COUNTY COUNCIL'S RESPONSE TO CONSULTATION ON THE FOLLOWING DEVELOPMENT PROPOSAL

Application No: 18/00825/HYBRID-3

Proposal: Demolition of buildings and structures as listed in Schedule 1; Outline planning permission for up to 1,175 new dwellings (Class C3); 60 close care dwellings (Class C2/C3); 929 m2 of retail (Class A1); 670 m2 comprising a new medical centre (Class D1); 35,175 m2 of new employment buildings, (comprising up to 6,330 m2 Class B1a, 13,635 m2 B1b/c, 9,250 m2 Class B2, and 5,960 m2 B8); 2.4 ha site for a new school (Class D1); 925 m2 of community use buildings (Class D2); and 515 m2 of indoor sports, if provided on-site (Class D2); 30m in height observation tower with zip-wire with ancillary visitor facilities of up to 100 m2 (Class D1/A1/A3); 1,000 m2 energy facility/infrastructure with a stack height of up to 24m (sui generis); 2,520 m2 additional education facilities (buildings and associated external infrastructure) at Buildings 73, 74 and 583 for education use (Class D1); creation of areas of Open Space, Sports Facilities, Public Park and other green infrastructure; Change of Use of the following buildings and areas: Buildings 357 and 370 for office use (Clas

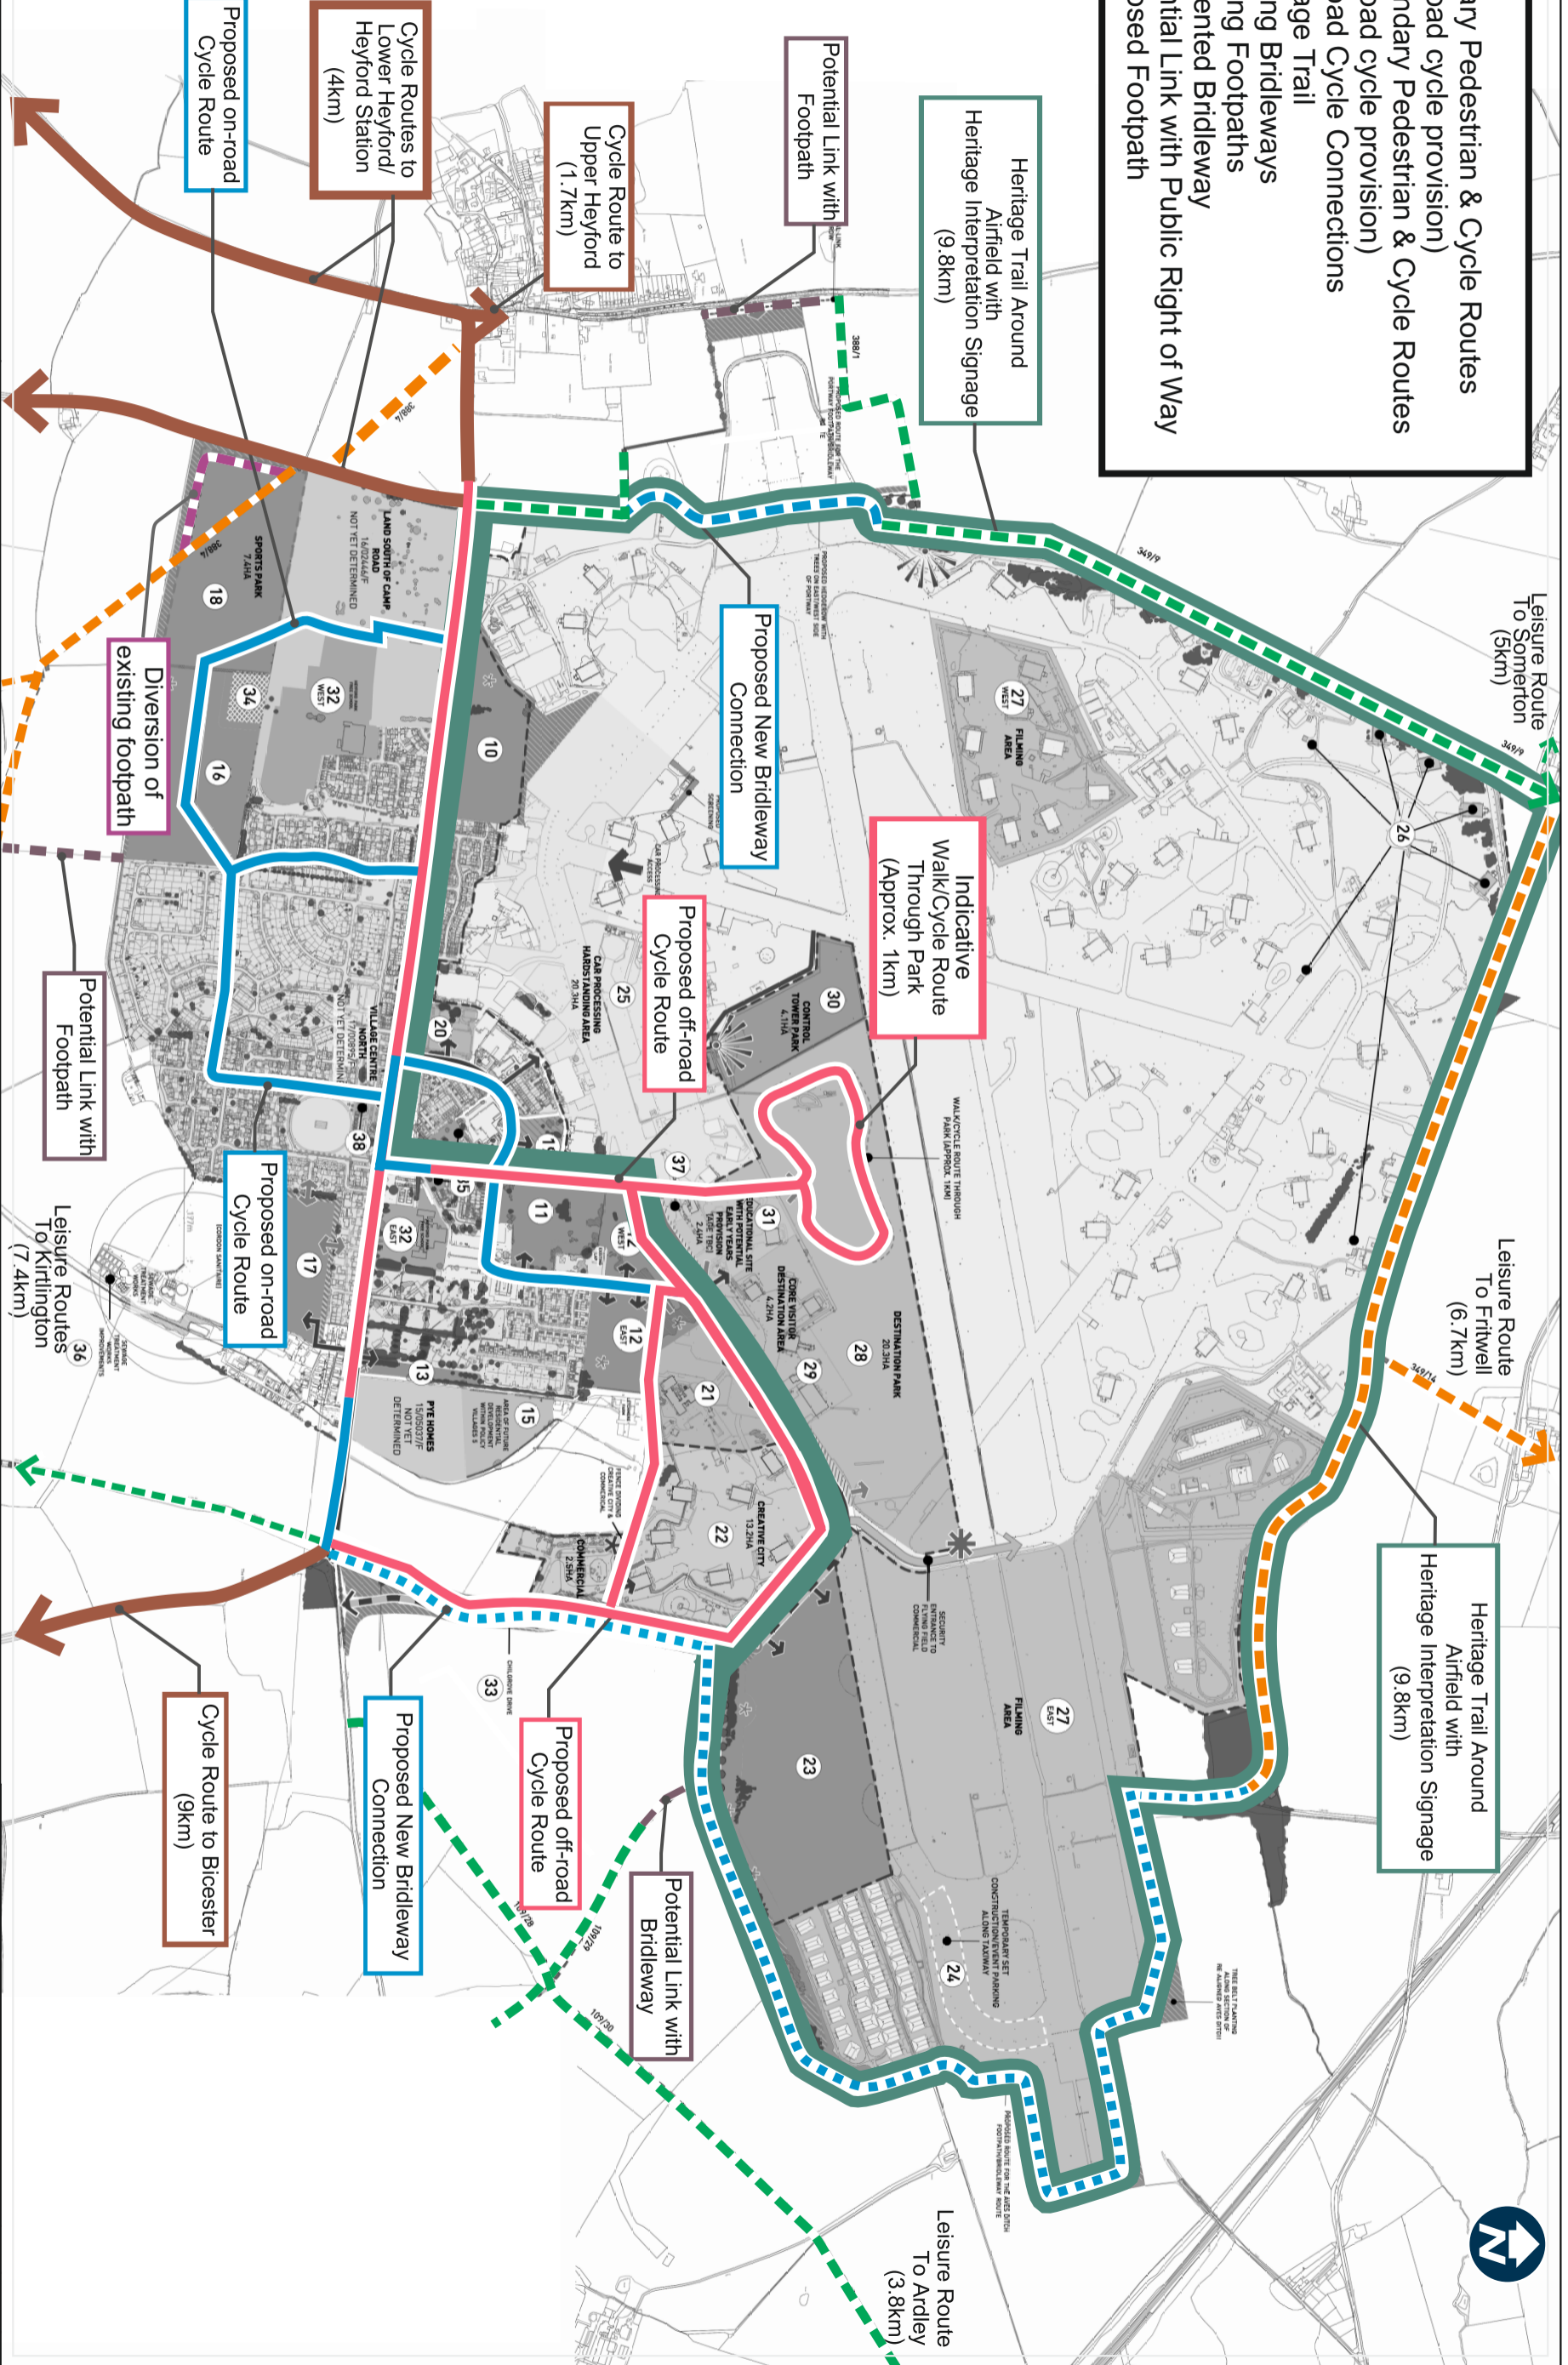
Figure 5.1 has been updated.

The routes to Upper and Lower Heyford are now marked 'Suggested on road Cycle Route to

Fig 5.1 should also be updated to include required public rights of way as discussed:

The plan does not show an acceptable route for the connection of Aves Ditch, which is a requirement of the current consent. There has been much discussion of the preferred route, and it is my understanding that the route below has been agreed (shown yellow in Fig 1), which is as per the 2012 agreement in principle, cutting across the 'nib' and including a stub to the Ardley railway bridge connection point. OCC would accept this not crossing the nib, provided the path in fig 3 below is provided, as that will provide PRoW users' experience of crossing the runway.

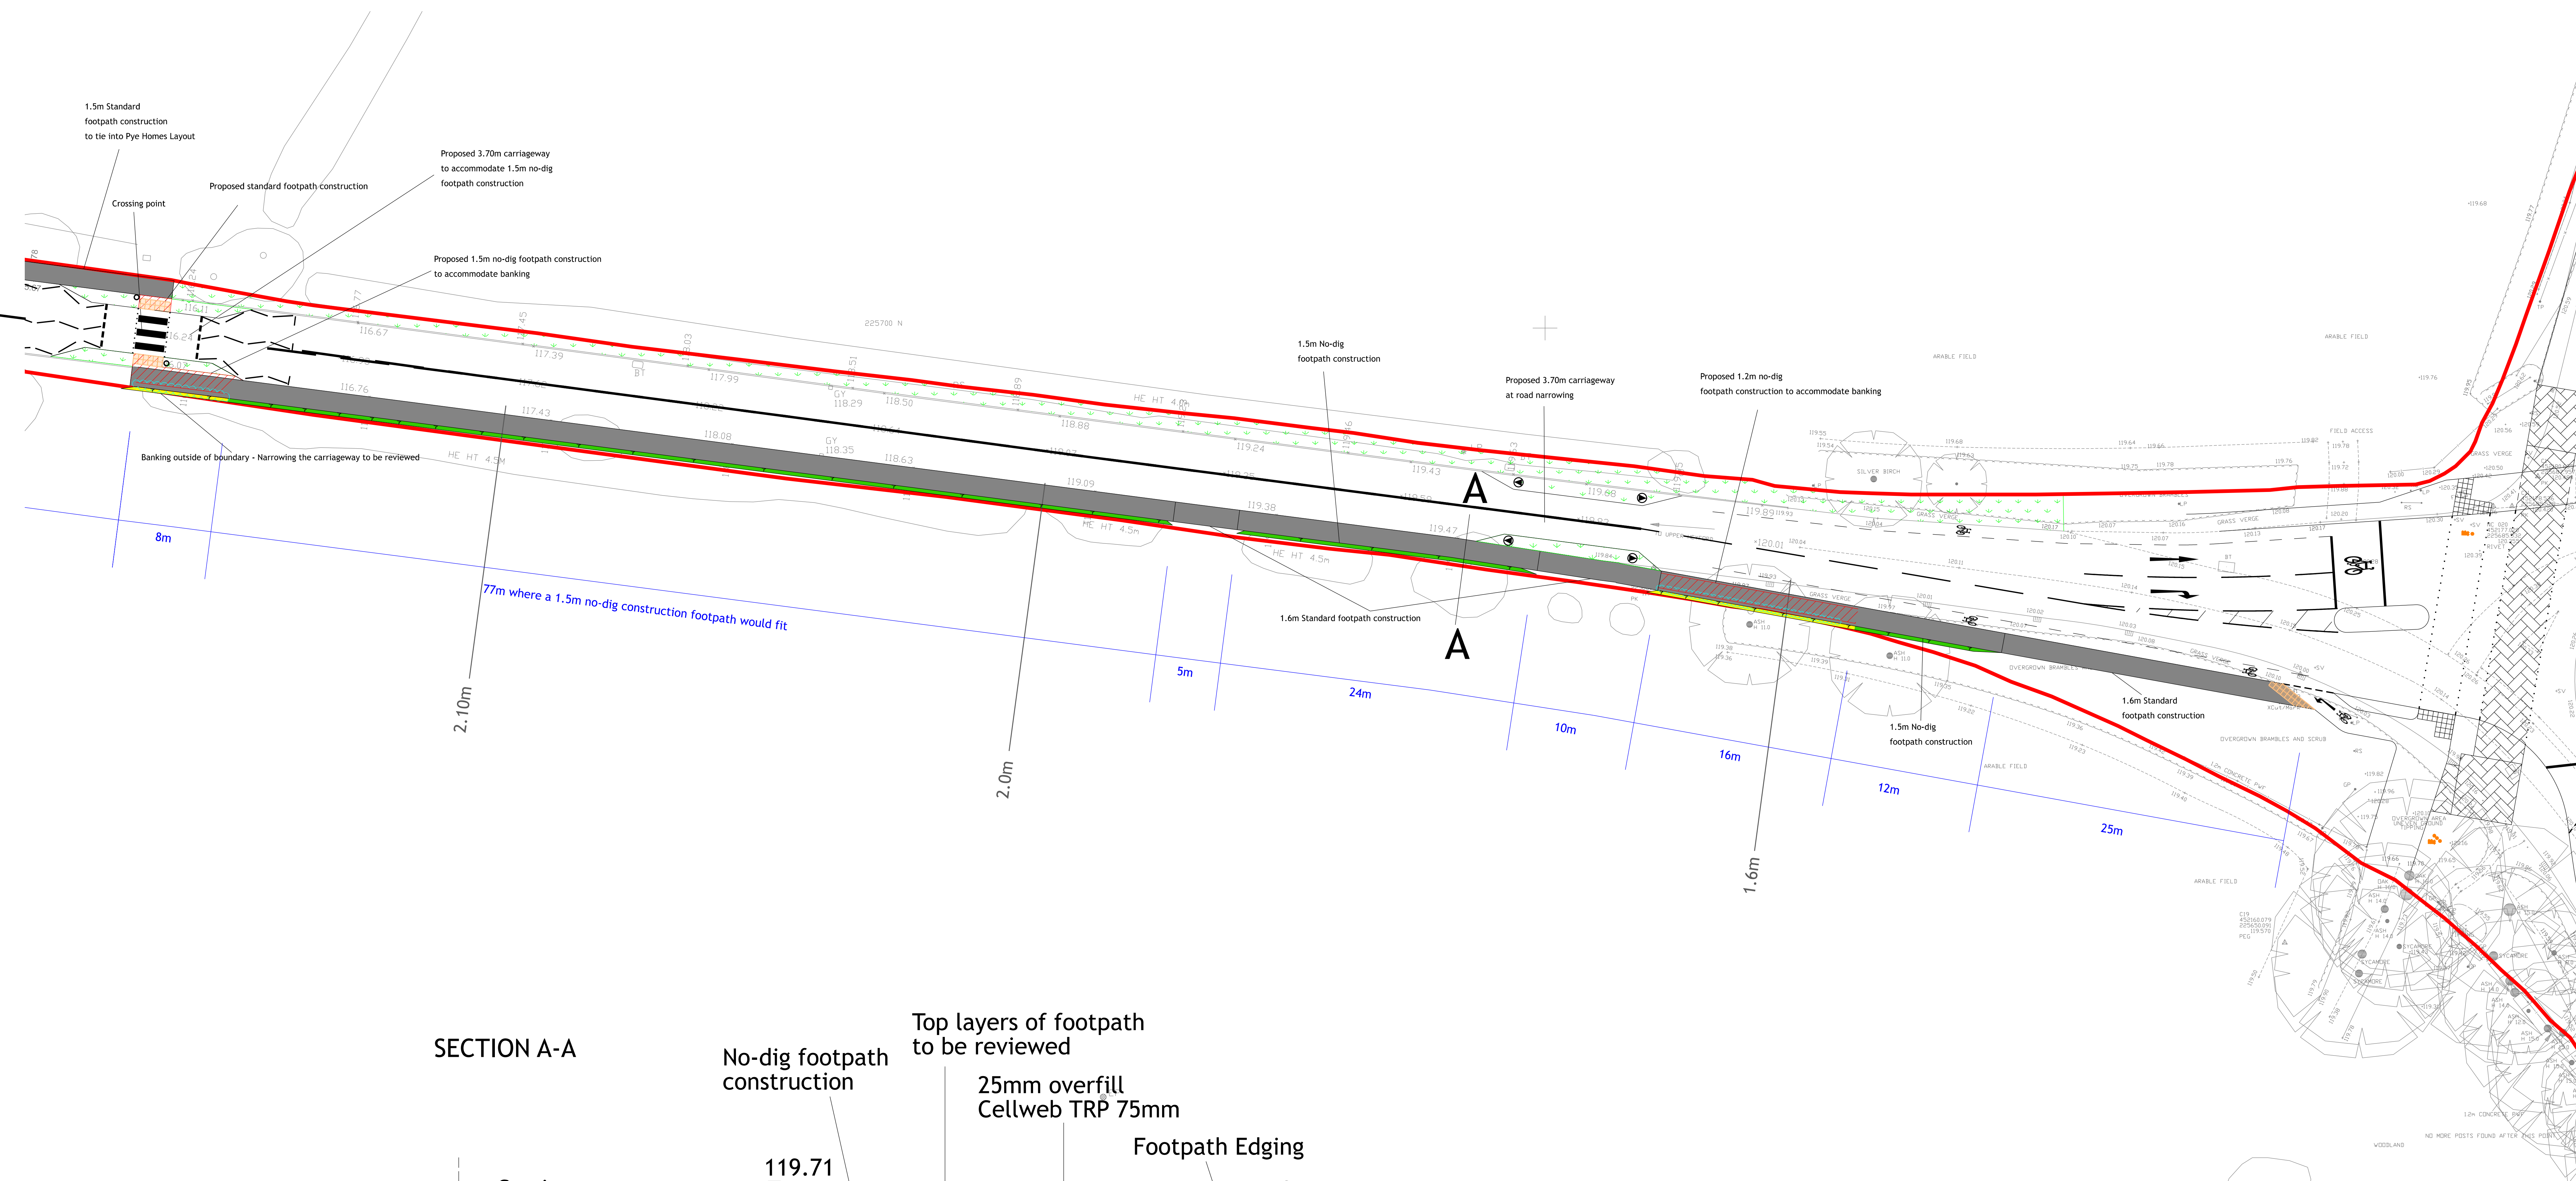
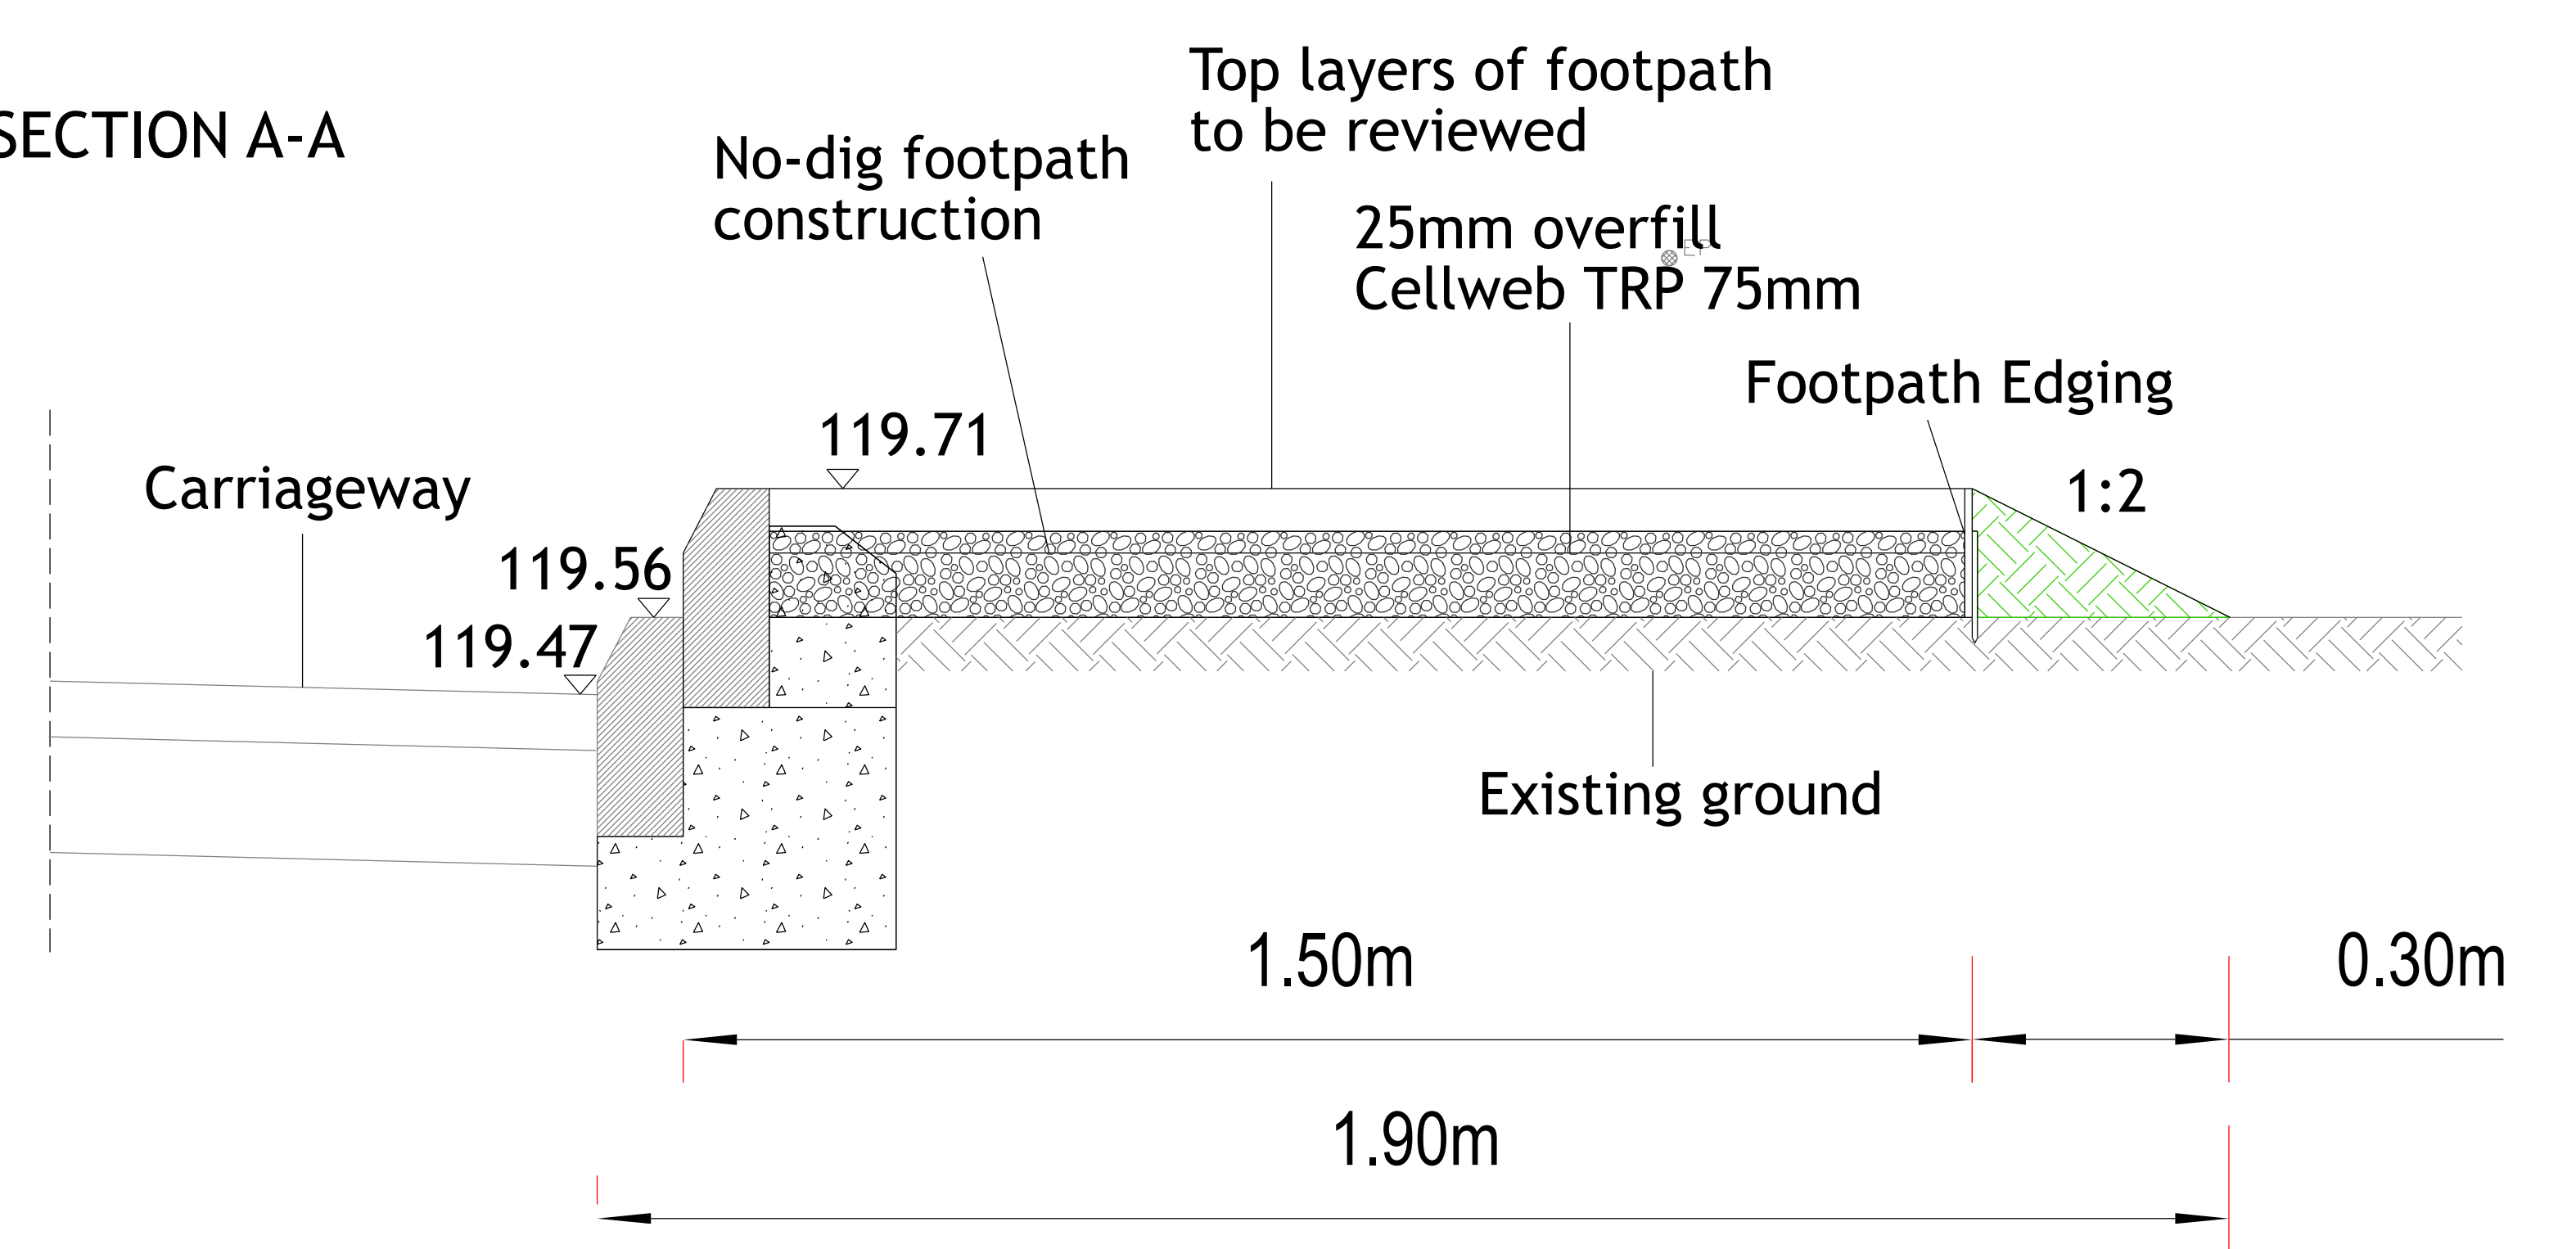
Footway on Camp Road.

Following a site visit I advised that, whereas any footway on the northern side of the link road would be too narrow to be acceptable, a footway of adequate width was, in my opinion, feasible on the south side. Following further investigation, the applicant has provided (email dated 15 July) a drawing (Woods Hardwick SK345E RevE) showing the footway crossing from north to south, east of the 'Pye Homes' site, to connect with the proposed crossing as part of the new junction with Chilgrove Drive. This connection will need to be made by the developer prior to first occupation of any residential or employment parcels accessed via Chilgrove Drive. (A footway connection between the existing footway on Camp Road to the west, and any further residential properties accessed from Camp Road east, must be made prior to first occupation of those dwellings).

The crossing point is proposed to be on a narrowing. Given the likely traffic volumes, I would like to see this formalised as a zebra crossing.

There is insufficient space to provide off carriageway cycle facilities, so further consideration in the design will need to be given to accommodating cyclists safely on the carriageway.

A revised drawing is requested.
